Application No: AB/114/20/PD
Site Address: Riverside House 2 Fitzalan Road Arundel BN18 9JS
Description of works: Notification for Prior Approval under Schedule 2 Part 1 Class AA for a additional 2 storeys on existing dwelling house.

Objection to Planning Application
AB/114/20/PD
Riverside House
2 Fitzalan Road
Arundel
BN18 9JS

PROPOSED ROOF PLAN

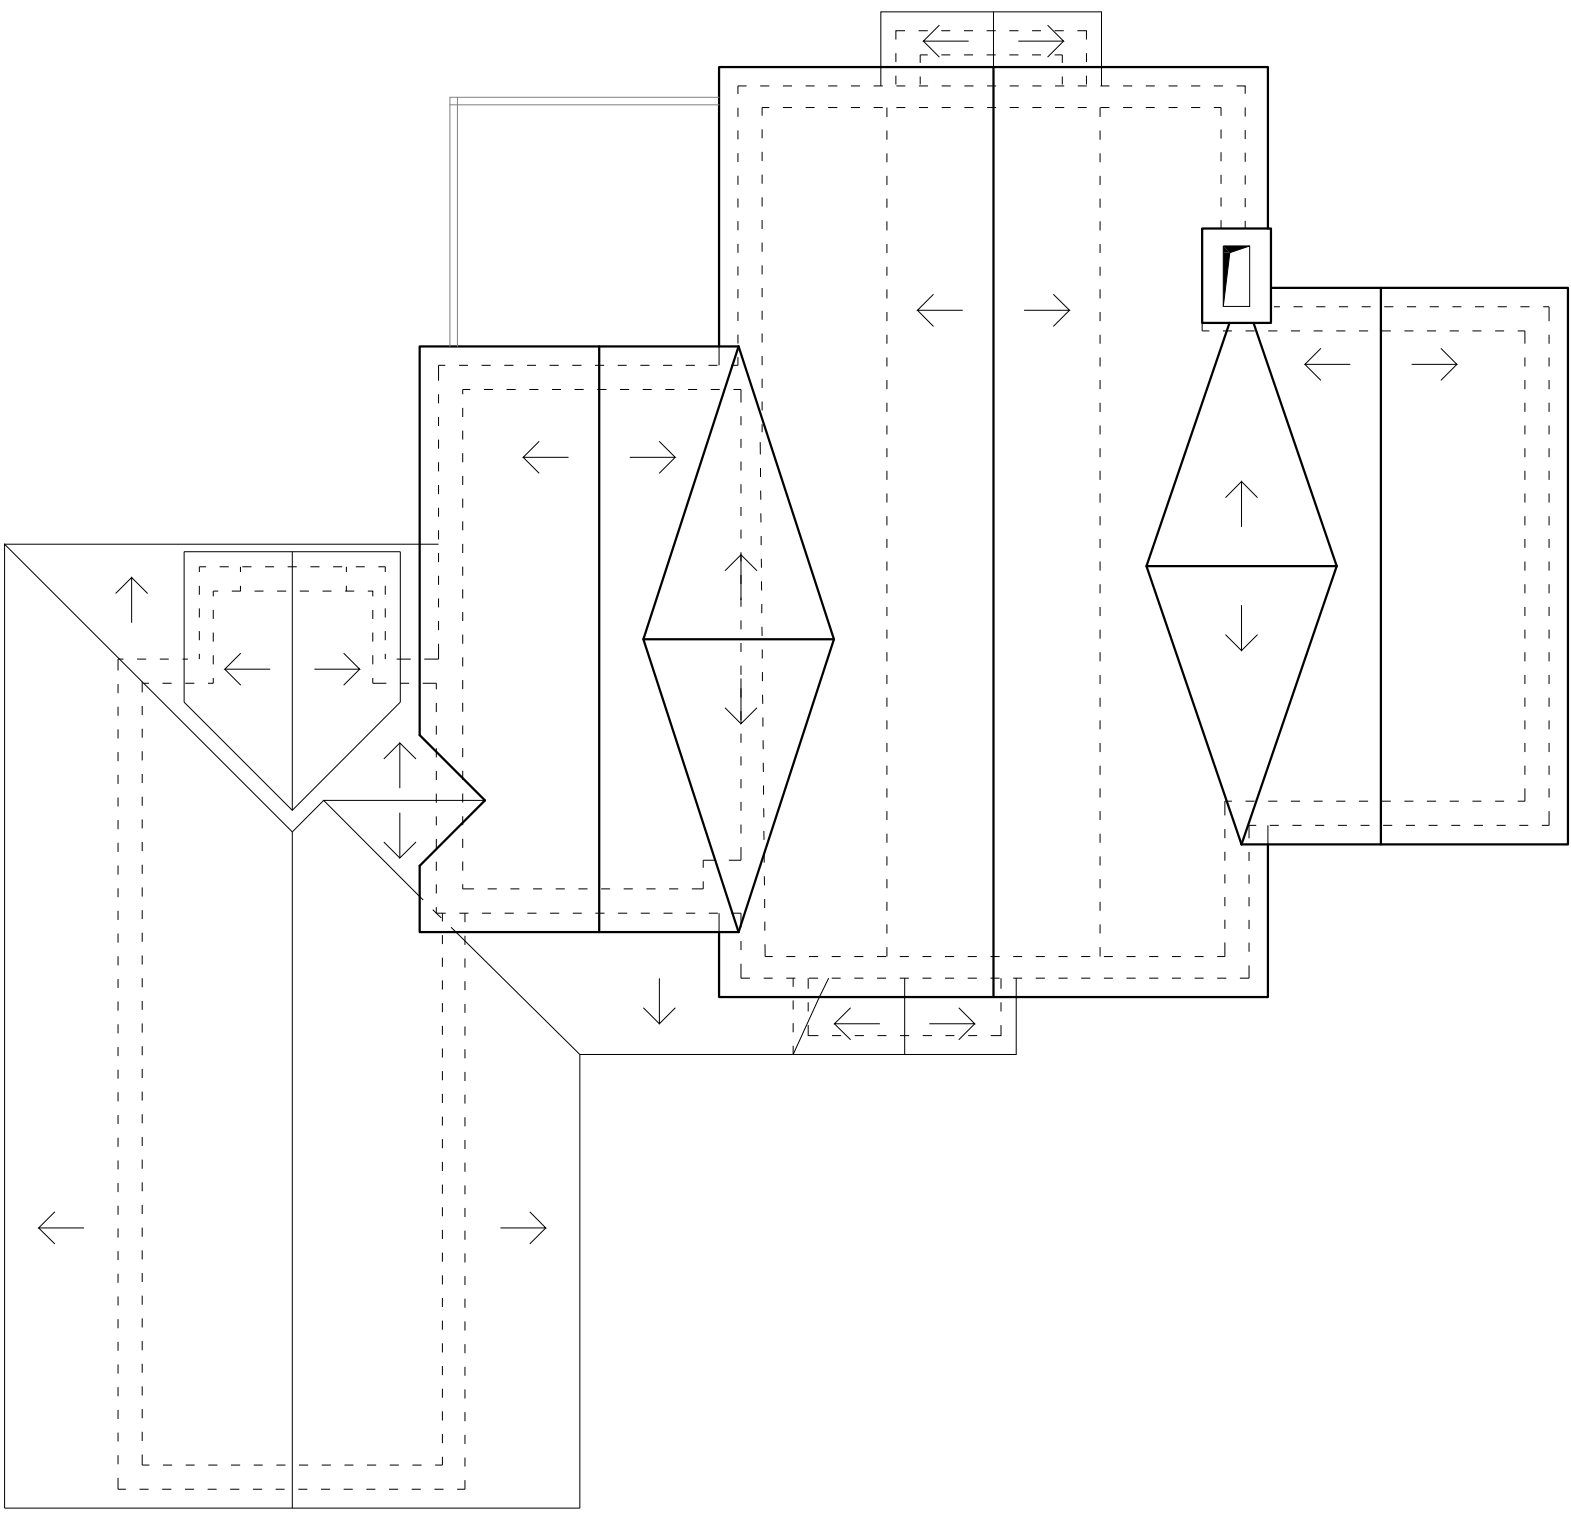
4. I note from the plans that there are some eleven proposed bathrooms, the future intent for which is surely a multi-occupancy dwelling of several flats. If this is indeed the case it should be declared as such, and not become an example of incremental development by stealth. If the intent is for a multi-occupancy building then parking requirements should be appropriately scaled, and the increase in traffic taken into consideration at this stage of the planning application.
